Application No: FG/64/25/HH

Site Address: 4 Sea Lane Ferring BN12 5DS

Description of works: Proposed flat-roof single storey rear extension, proposed elongated windows to western elevation, erection of double carport to replace garage and new front gate.

Thank you for your internet representation made on 24th June 2025 which has been recorded as an objection with the comments as follows:

Drawing: **PL01D**

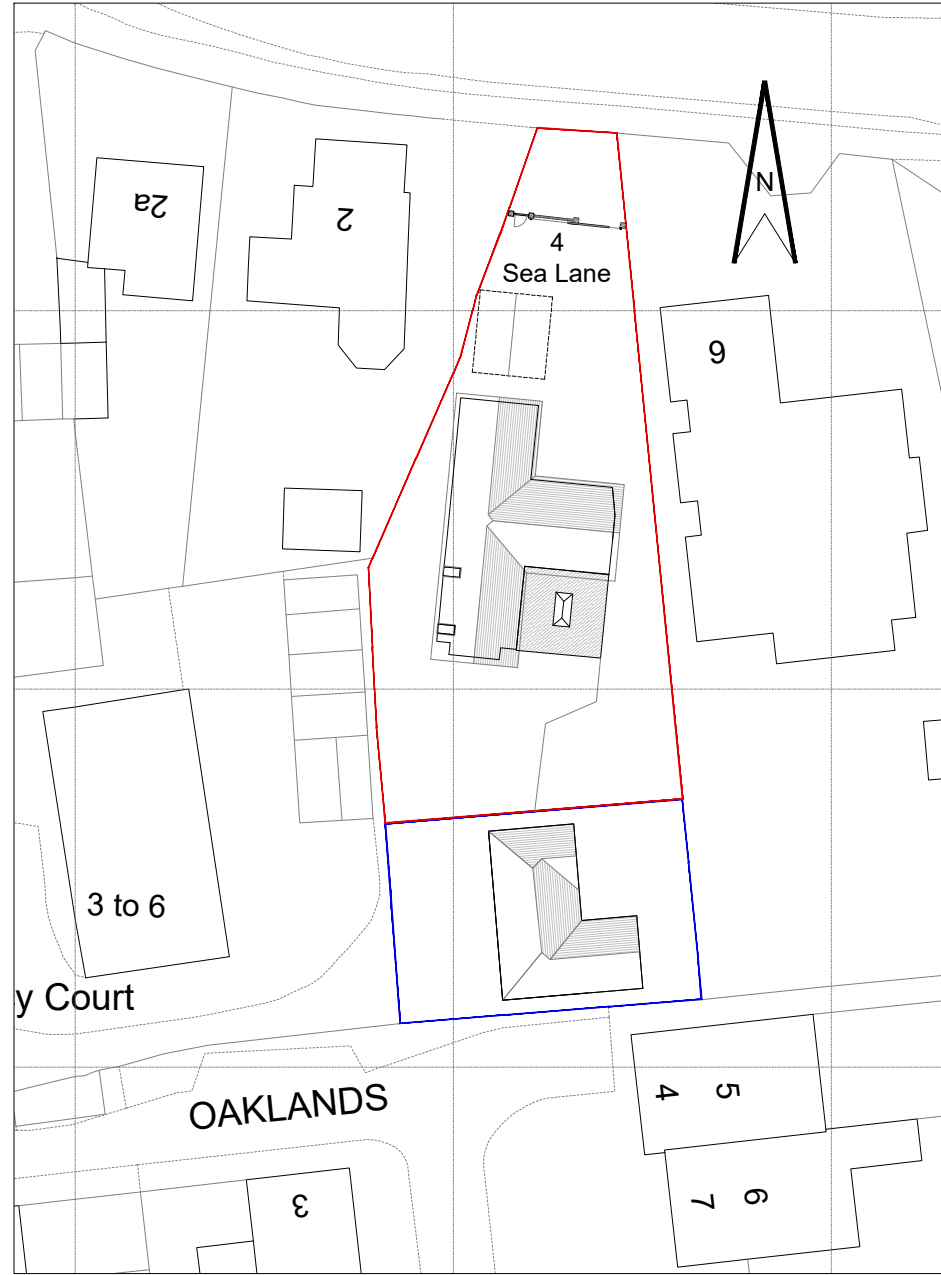
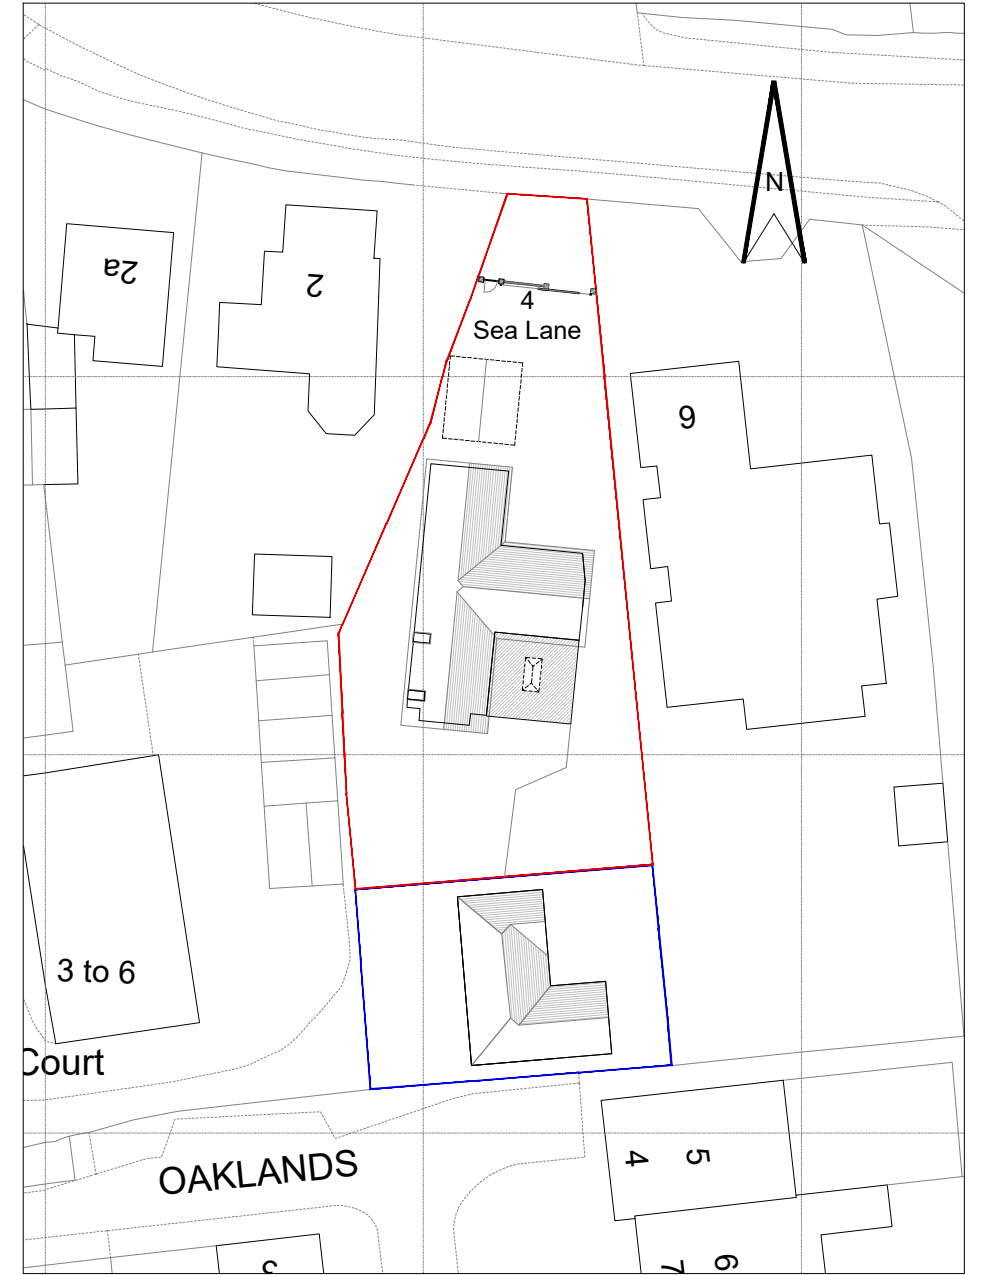
It is also unclear which direction the proposed ridge line is running. The uploaded documents provide conflicting information (PL01D, PL03D & PL04B). A ridge line running East/West would be the worst-case scenario for us, with the Gable End predominant visible over our boundary fence - exacerbated by being only 0.3m from the boundary at its closet point.

25.313 Drawing: PL03C

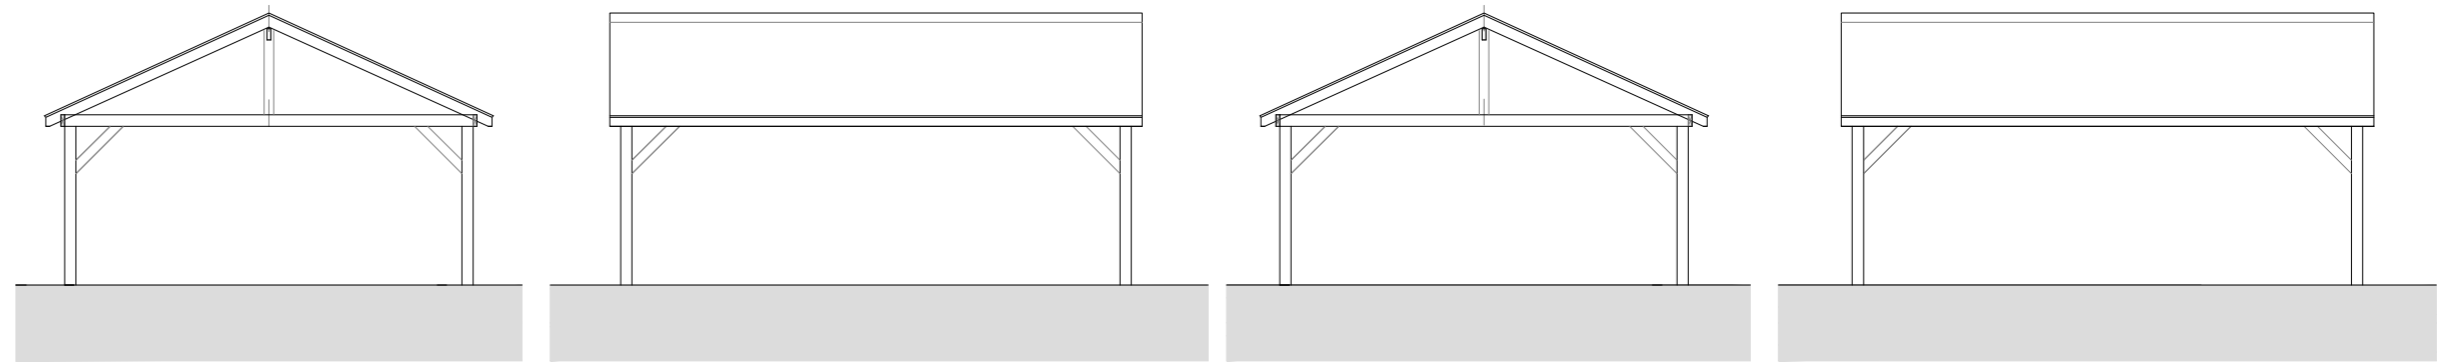
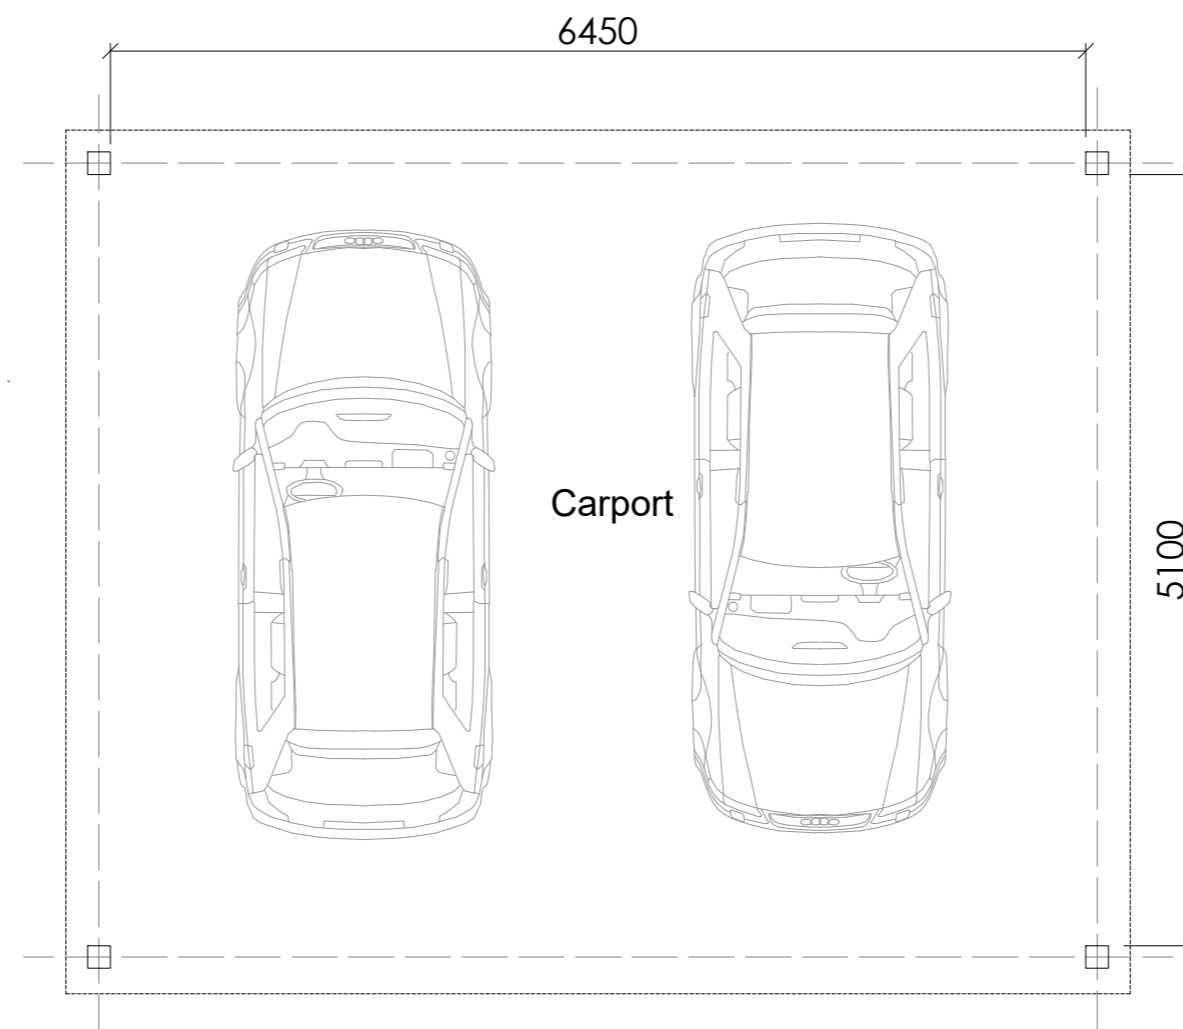
We have concerns about the Car Port adjacent to the eastern boundary of 2 Sea Lane. Primarily due to the height of the structure and its proximity to our property.

Whilst there are no specific boundary distances or vertical dimensions in the uploaded documents relating to the structure, scaling from the drawing shows the ridge line is approximately 3.8m high. To put it into perspective, 3.8m is level with our first-floor windowsills.

Our lounge is the primary living space and has double doors (East facing) leading to the patio area with established borders and a greenhouse. The proposed Car Port would overshadow these areas.
